Please ask for: Sian Eggington
Email: sian.eggington@terraquest.co.uk
Telephone: 0121 2341390
Our Ref: BR/115/20/HH
Your Ref:
Date: 28th May 2020

Application for Planning Permission for Works or Extension to a Dwelling

Development: Single storey rear extension.
Location: 6 Highcroft Crescent Bognor Regis PO22 8DH

Floor Plan	Scale: 1-50 @ A3	CLIENT: Mr & Mrs Szarowicz 6 Highcroft Crescent Bognor Regis PO22 8DH		CHECKED:	DRAWING NO: AZ-P-03	REV:
		PROJECT: Rear Extension and alterations		DATE: 17-05-20

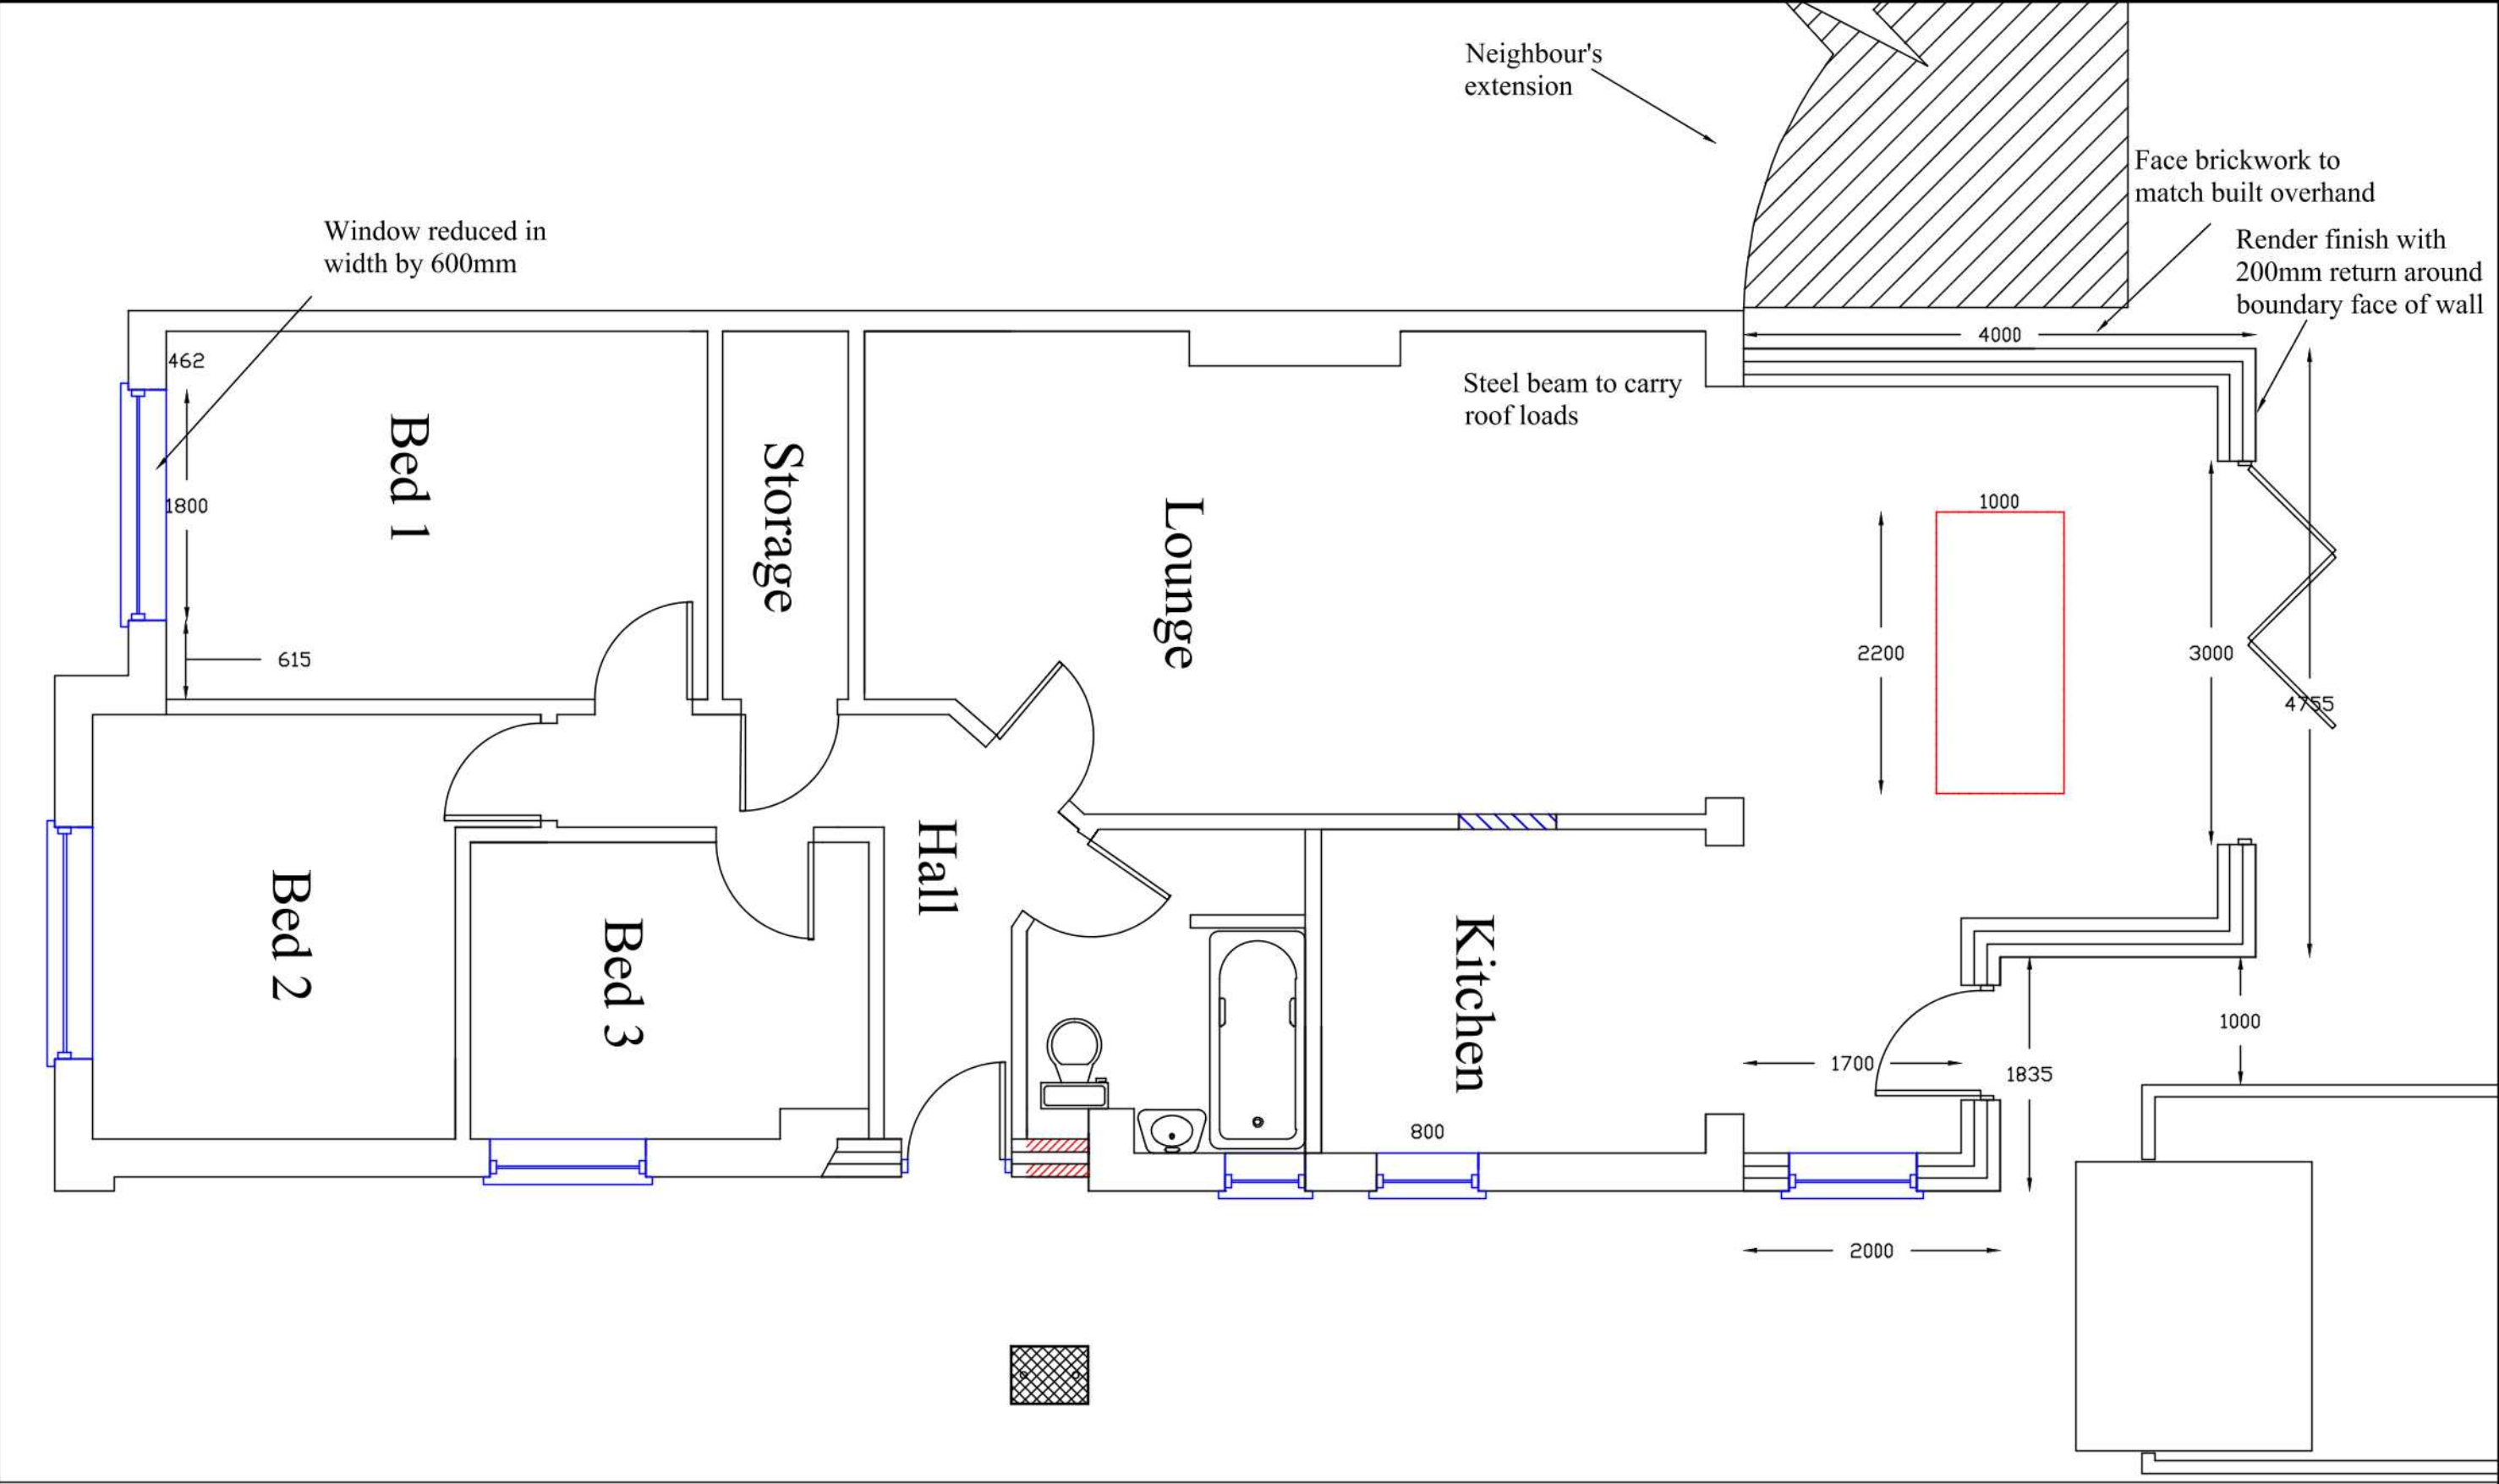
Scale: There is no scale on the proposed floor plan. Please amend.
